RE: Notice of Exhibition – The New Sydney Fish Market – Concept and Stage 1 (SSD – 8924)

I refer to your email dated 11 October 2019 inviting comments and advice from the Heritage Council of NSW for the above State Significant Development application for the New Sydney Fish Market. The proposal involves a concept development application for the New Fish Market and Stage 1 comprising of demolition and repairs to the existing sea wall.

Figure 11: Indicative distribution of archaeological test excavations (Land and Property Information Place Point map in QGIS)

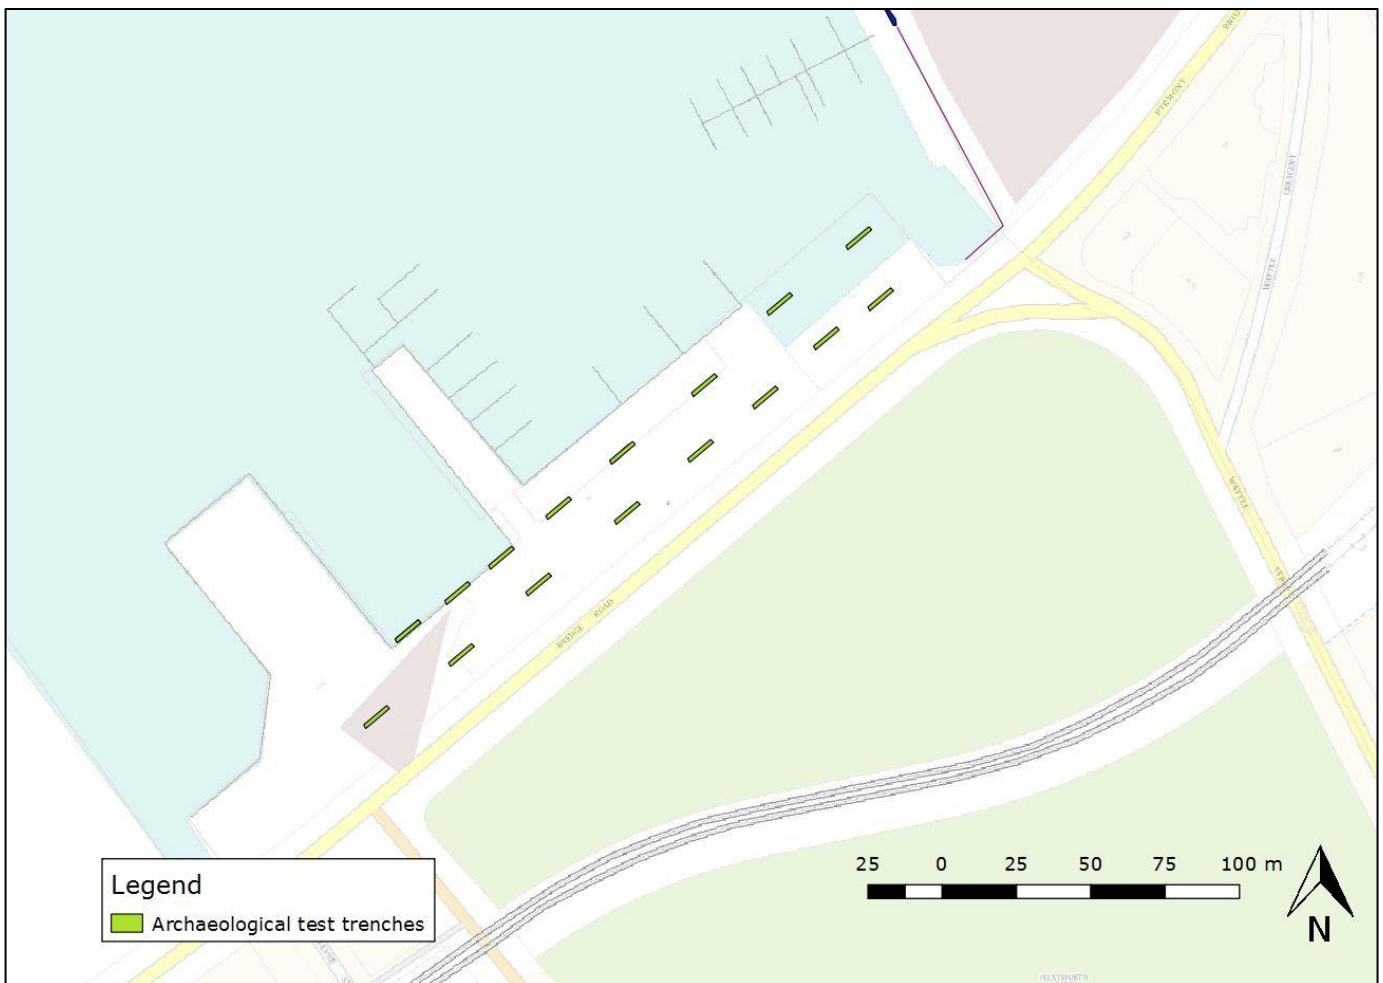
substantiated, for example the claim that any 'relics' washed into the Bay from stormwater drains would be of significance. The HIA has recommended a series of mitigation measures to be undertaken. These include a heritage site induction to be undertaken by all employees, contractors and subcontractors. Monitoring by a suitable qualified and experienced archaeologist and the archaeological test excavation strategy as identified in Section 7 of the HIS. It is recommended that the mitigation measures and archaeological test excavation strategy outlined in the HIA be adopted and implemented.
